**WELWYN HATFIELD BOROUGH COUNCIL
EXECUTIVE DIRECTOR - PLANNING, PUBLIC PROTECTION AND GOVERNANCE**

Application No: 6/2022/0669/HOUSE
Location: 99 Bramble Road Hatfield Hertfordshire AL10 9SB
Proposal: Erection of a single storey front extension and two storey side and rear extension.
Officer: Ms Kirsty Shirley

Recommendation: Granted

2022 / 09 / 01 **A1**

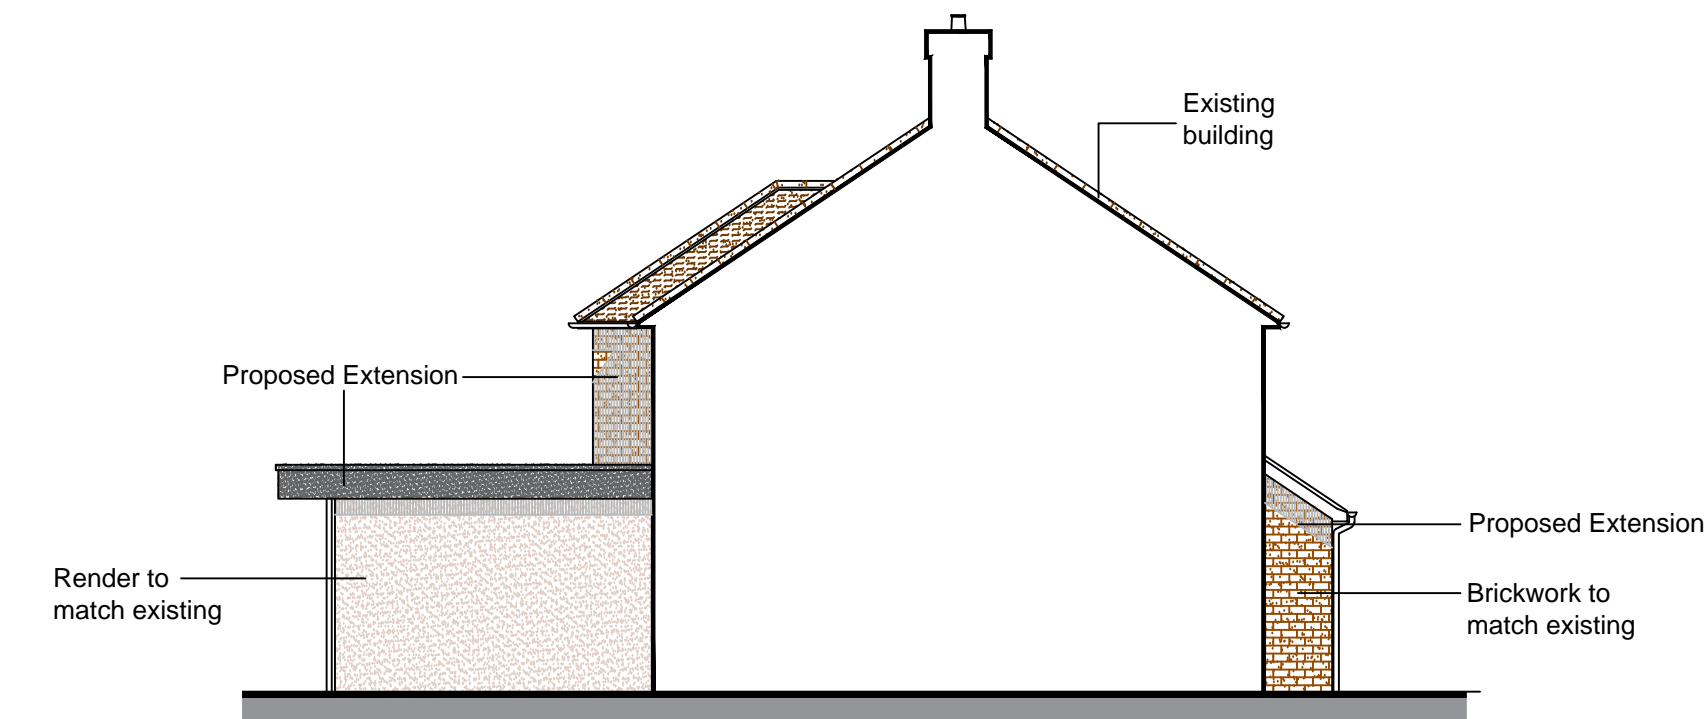
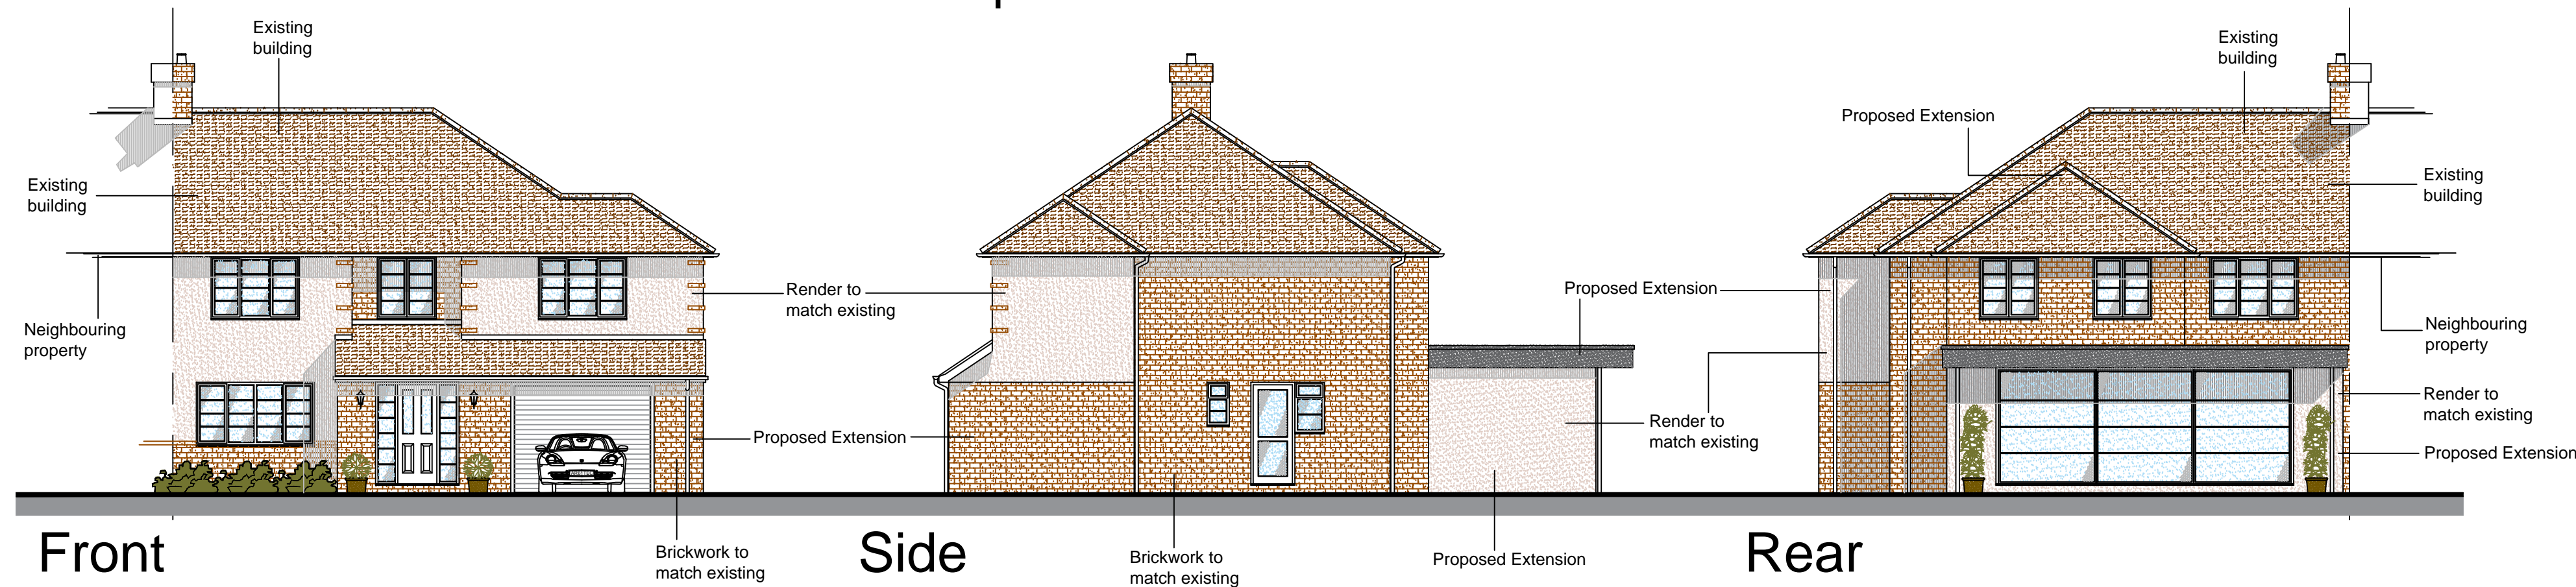
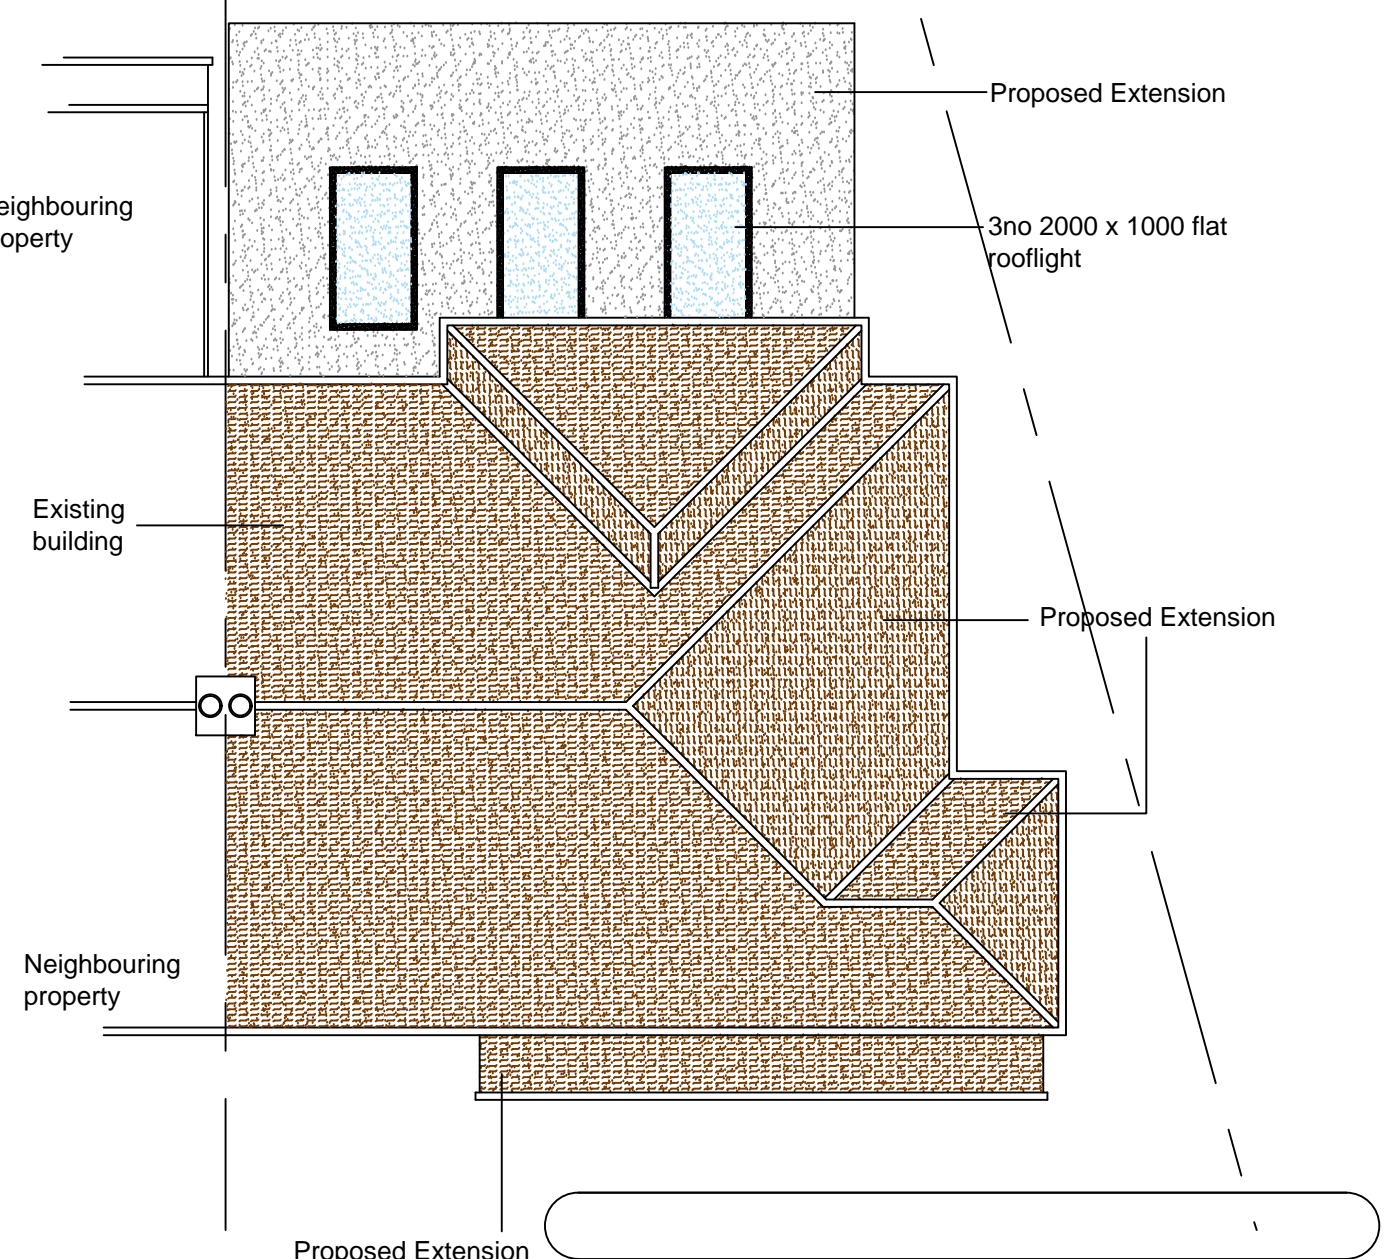
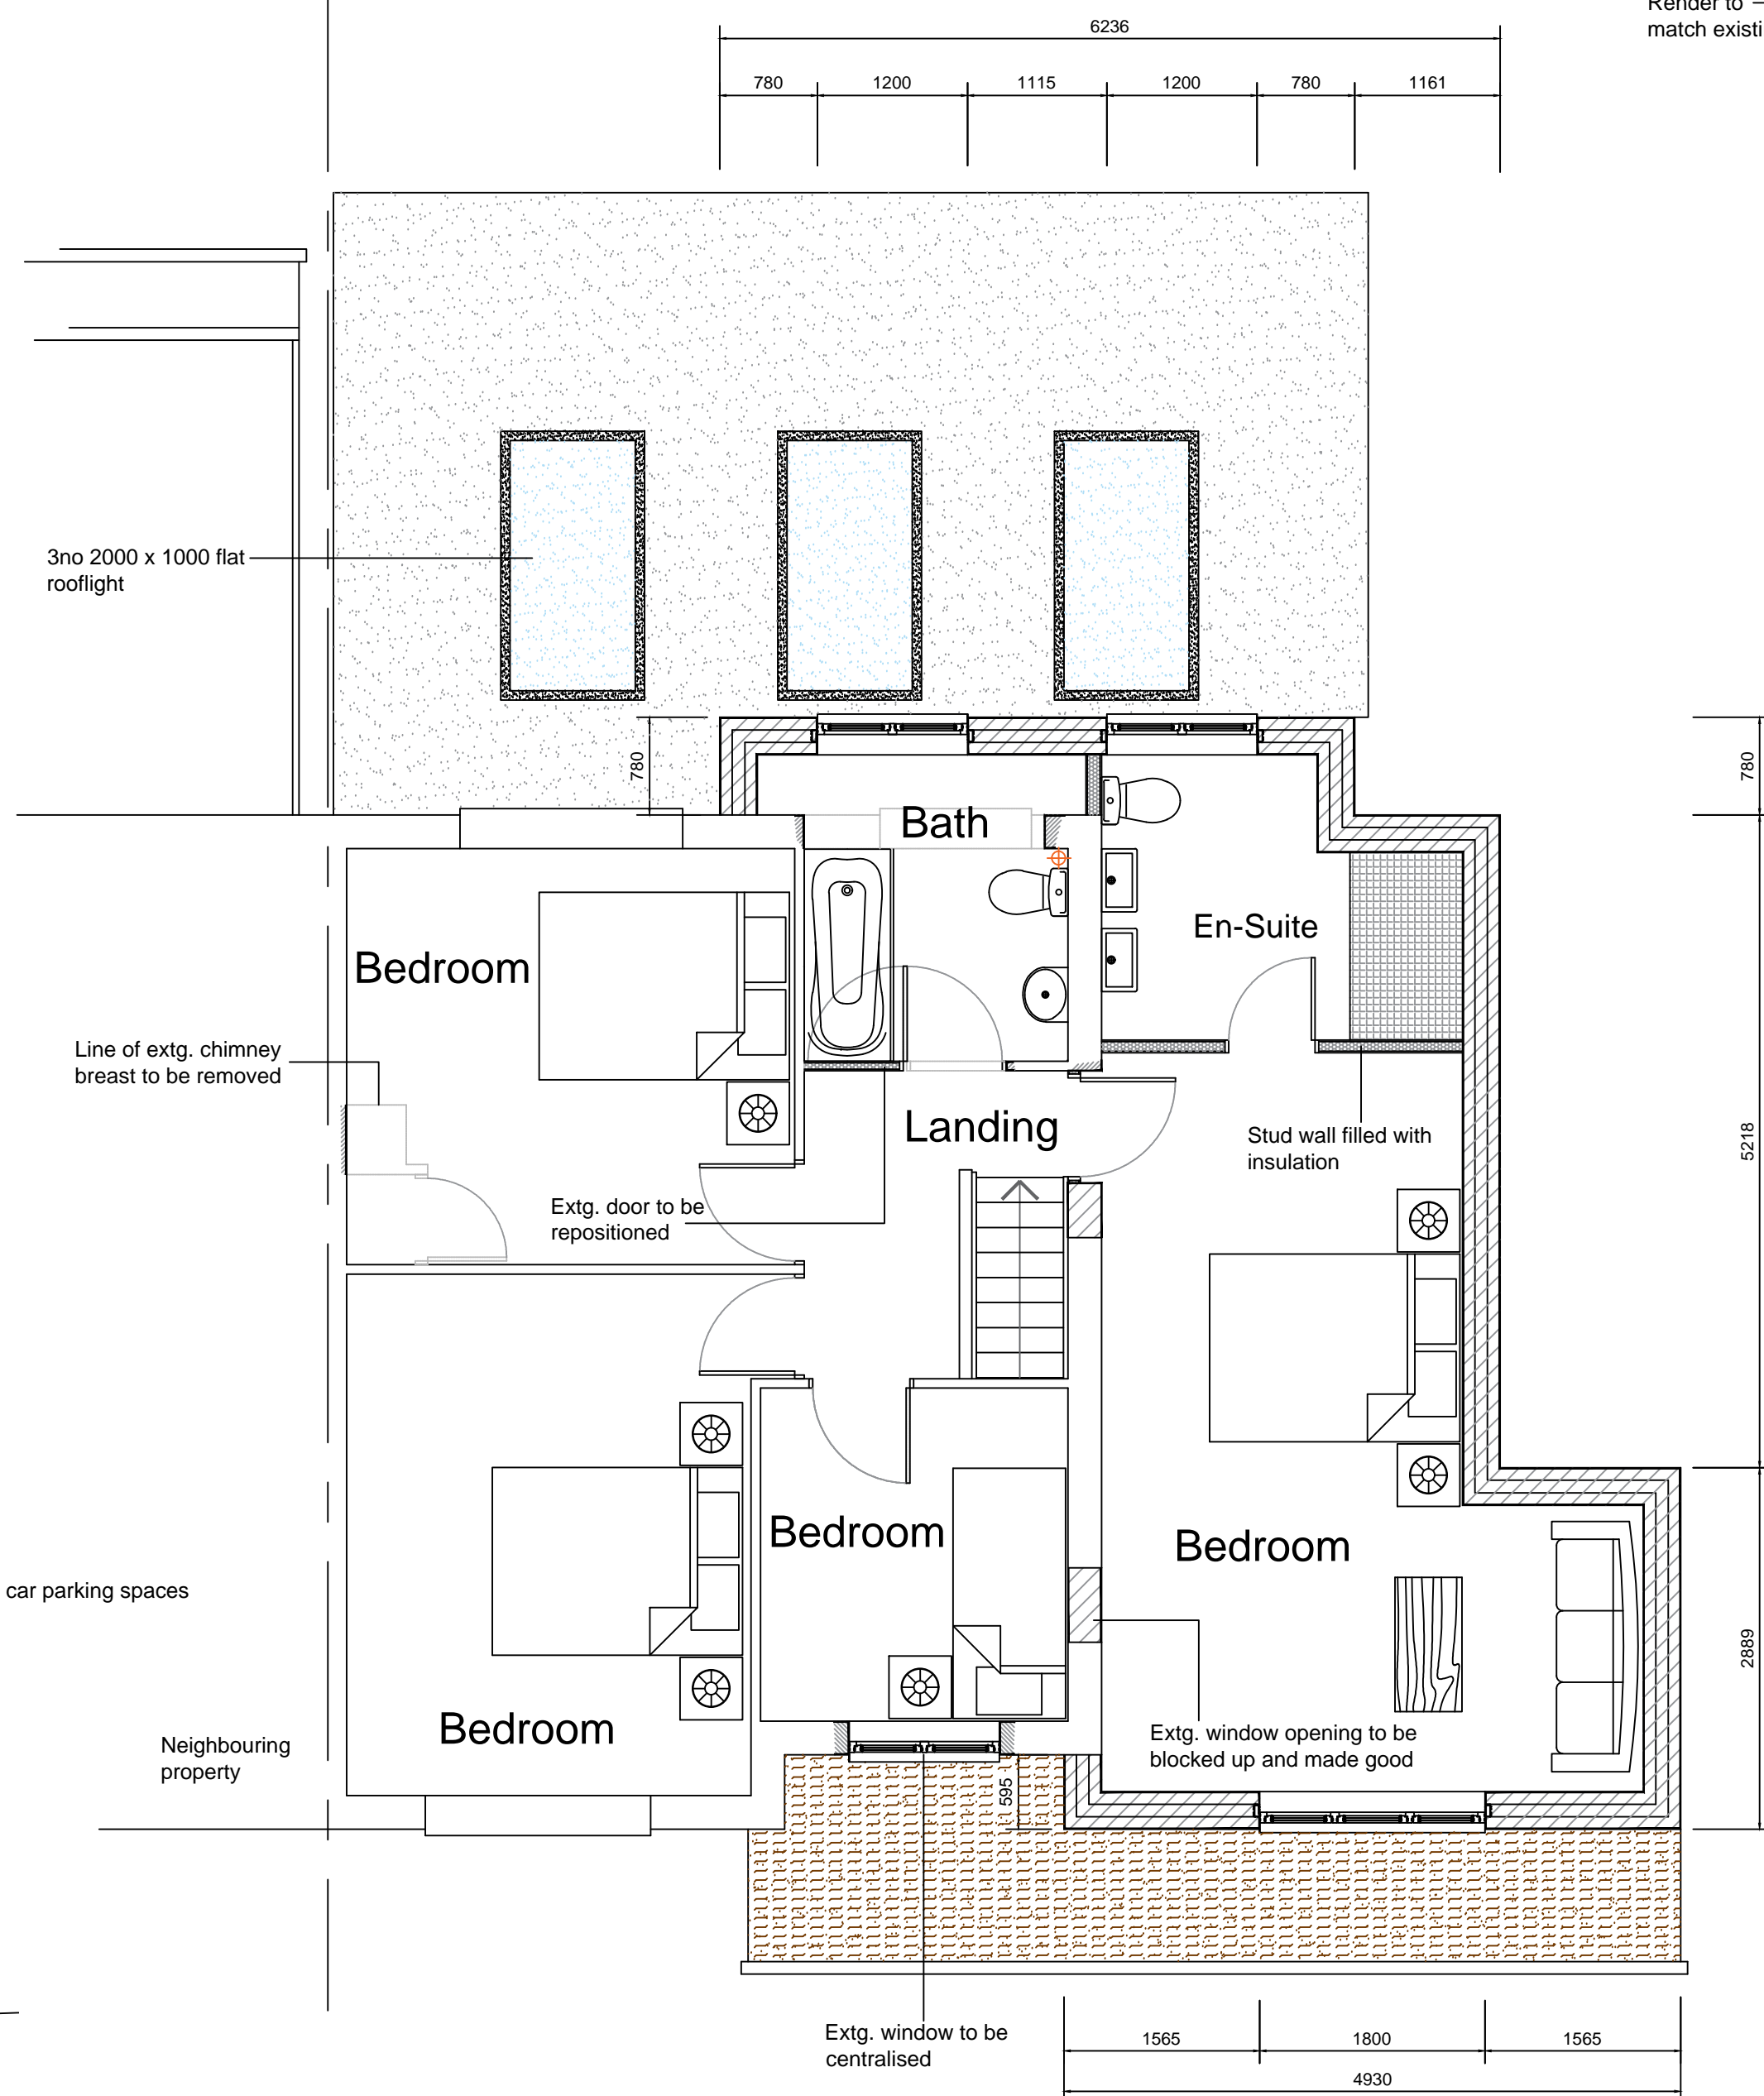
The proposed front extension would project forwards by less than 1m and would extend across approximately two thirds of the front elevation of the dwelling. The size and scale of the single storey front extension would appear subservient to the existing dwelling. The front extension would feature a monopitch roof which would be in keeping with the hipped roof of the dwelling.

The proposed ground floor rear extension would project across most of the width of the rear dwelling. The first floor rear extension would project across just over half the width of the first floor width of the dwelling, and would project less than 1m from the first floor rear elevation of the dwelling. The first floor rear extension would feature a hipped roof in keeping with the application dwelling and the ground floor rear extension would feature a flat roof, which would not be objectionable given the scale and positioning of the ground floor extension.

The application site has a splayed boundary with adjoining neighbour No. 101 Bramble Road. The development would set back the ground floor flank elevation facing towards No. 101 from the splayed boundary, which currently has a very minimal distance from the boundary at first floor level.

There are many examples of first floor side extensions within the street scene. Spacing at first floor level between boundary lines is noted within the area, with many first floor side extensions set in noticeably from the boundary line at first floor level. The proposed first floor side development would respect the spacings at first floor level noted within the area. The first floor side extension would finish in line with the flank elevation of the garage, which would be further set in from the boundary line with No. 101 as part of this development. The minimum 1m separation distance between the first floor flank elevation of the extension and flank elevation of No. 101 would be maintained. The first floor extension would therefore be in accordance with the Council's Supplementary Design Guidance.

In regards to privacy, no windows would be inserted into the first floor side elevation facing towards No. 101. A further first floor window would be inserted into the front facing elevation with sliding doors inserted into the ground floor rear elevation and three windows inserted into the first floor rear elevation. It is considered that there would be sufficient spacing between the application dwelling and neighbours located opposite the development to prevent a detrimental loss of privacy to these neighbours. No neighbours adjoin the site to the rear.

1. The brickwork, roof tile, bond, mortar, windows, detailing, guttering, soffits and other external decorations of the approved extension must match the existing dwelling in relation to colour and texture.
